DOC18/894242  
SSD 5175 MOD 4 & SSD 8588 MOD 2

**Exhibition of Modification Requests for the Eastern Creek Business Hub, Rooty Hill Road South, Eastern Creek - SSD 5175 MOD 4 (Concept Plan) and SSD 8588 MOD 2 – (Lot 2 Stage 1)**

**Attachment 1 – Office of Environment and Heritage (OEH) comments Exhibition of Modification Requests for the Eastern Creek Business Hub, Rooty Hill Road South, Eastern Creek - SSD 5175 MOD 4 (Concept Plan) and SSD 8588 MOD 2 – (Lot 2 Stage 1)**

Figure 28: Super lot subdivision

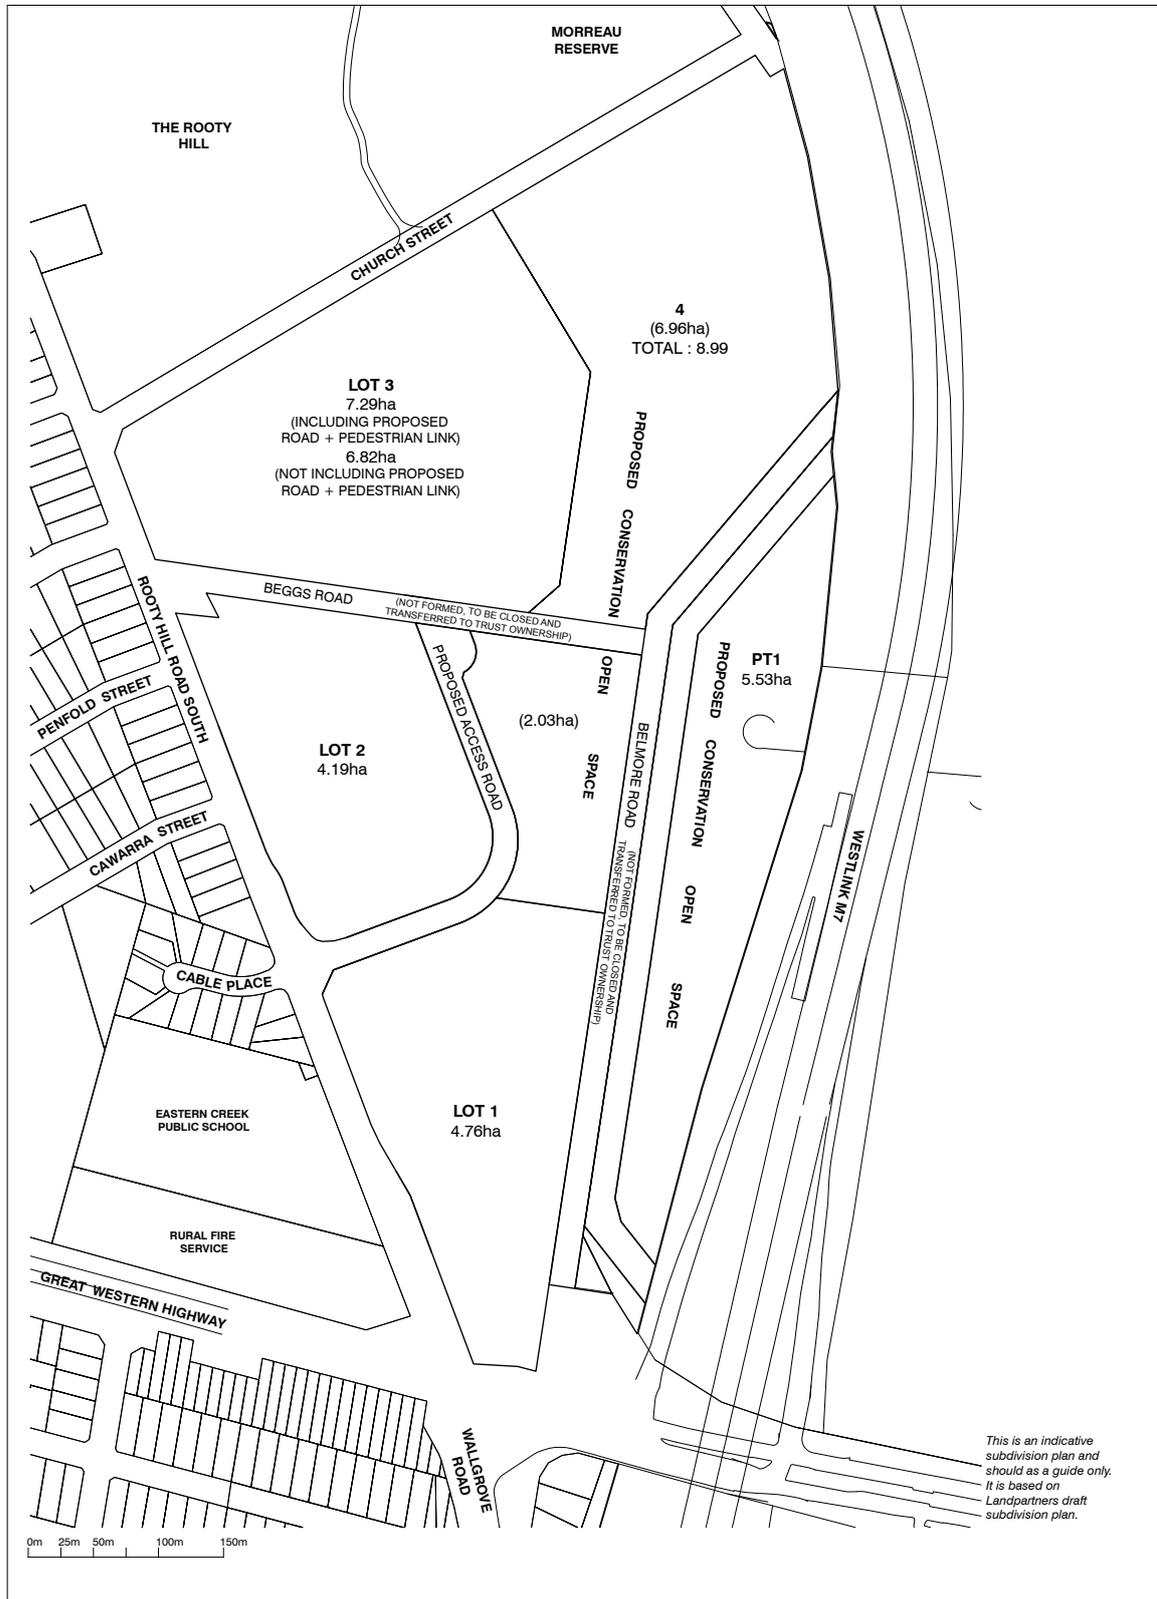
The amended subdivision plan submitted with SSD 5175 MOD 4 shows the CPW area to be protected as 6950m<sup>2</sup> which is less than the original concept plans. OEH requires this matter to be clarified and consistent with the original concept plans. The Development Consent determination for SSD 5175 Concept plan included the rehabilitation of the existing woodlands area on site identified for conservation area/open space.

The Ecological Australia letter dated 26 September 2018, states there will be a net reduced impact on native vegetation of 0.017 ha as a result of the modifications. However, the amended subdivision plan shows CPW at 6950m<sup>2</sup> which is less than the original concept plan area of SPW and OEH needs clarification to ensure it is equal to the required offset on site.

Figure 1 – Provides clarity around the decreased impact to Shale Plains Woodland (SPW) and the removal of any impacts on Alluvial Woodland (AW), providing decrease in impacts to native vegetation.

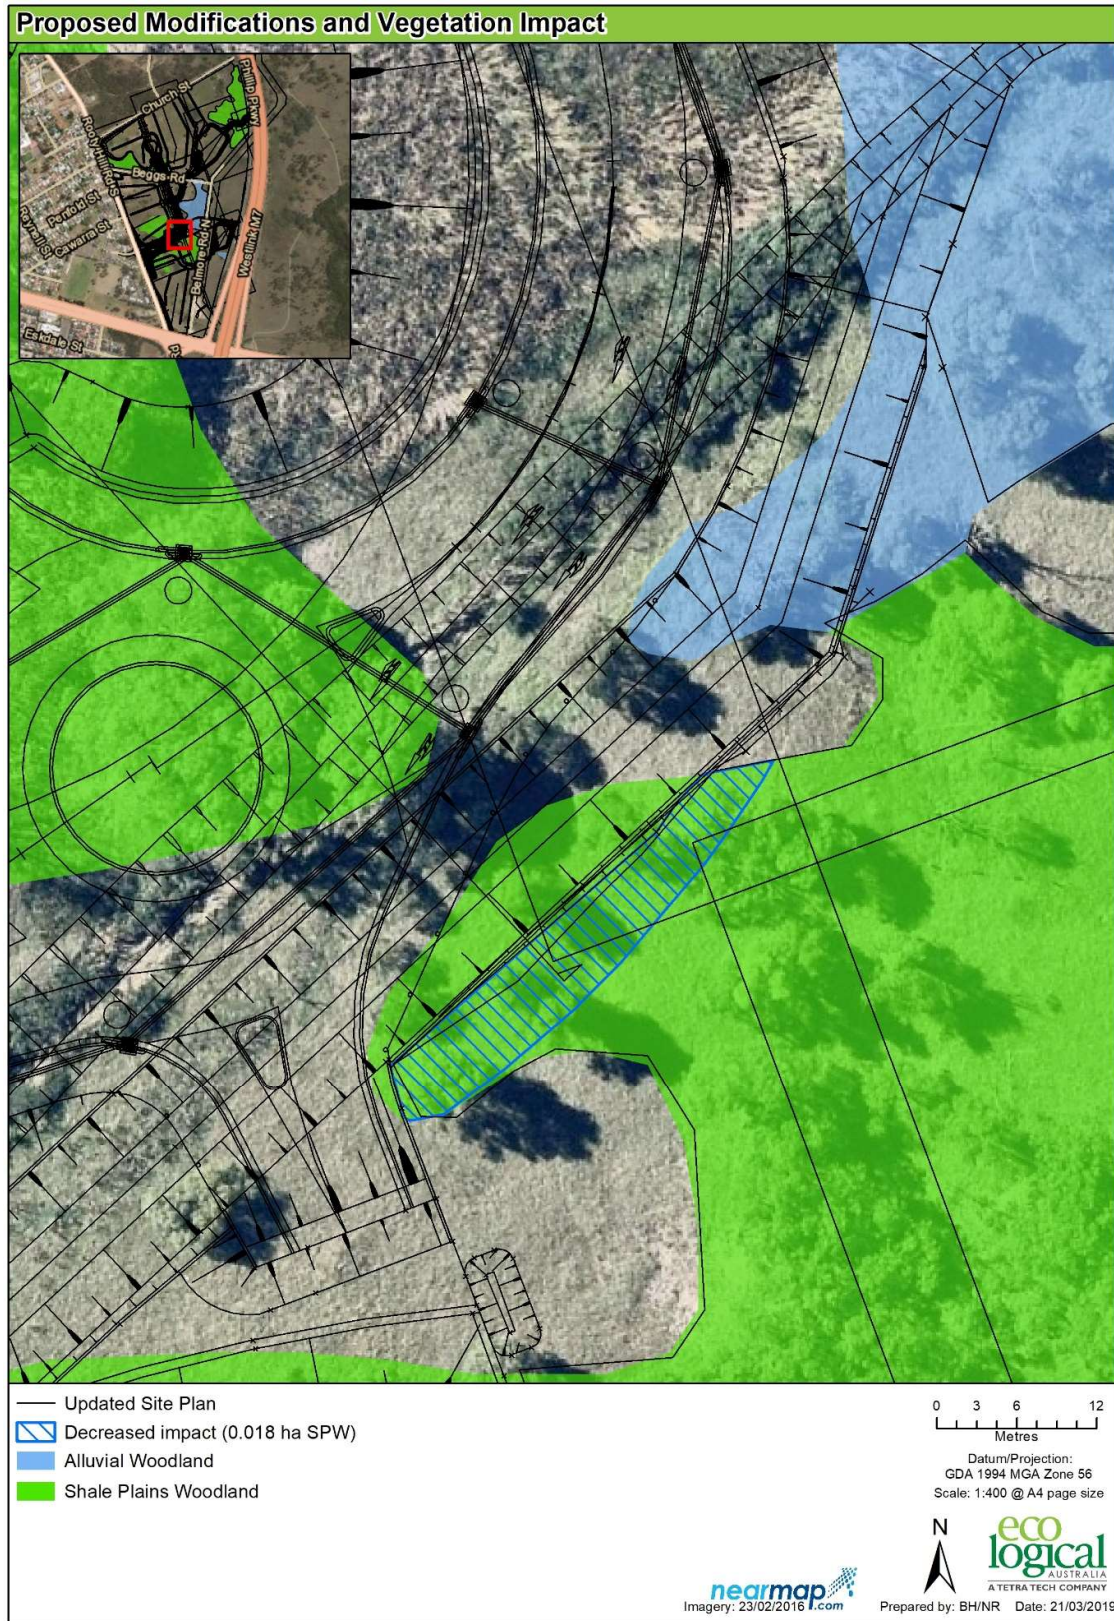
1. The modification proposes to relocate the main 4m wide overland stormwater flow channel. It appears that this may impact on the site's proposed offset area. In the BDAR waiver for SSD 8588 (OEH reference DOC18/148984) Ecological Australia's submission stated that the Derived Native Grassland area (DNG) is part of the proposed offset area in the subject land and forms this open drainage channel. OEH requires a clear plan showing the proposed offset area on site, that also clearly shows the proposed modifications and the vegetation area impacted at a scale that is clearly visible. The plan provided in Ecological Australia's document dated 26 September 2018 extracted below is unclear.

2. The comparison of the 'approved' and 'proposed' plans for the design of the Stage 1 lot as shown in Figure 2 extracted below, indicates that the overland flow channel marked in green around the proposed Building 1 envelope is smaller compared with the approved diagram. If this overland flow channel forms part of the on-site offset, it appears that the offset has been reduced in size. OEH requires clarification on this aspect of the proposal.
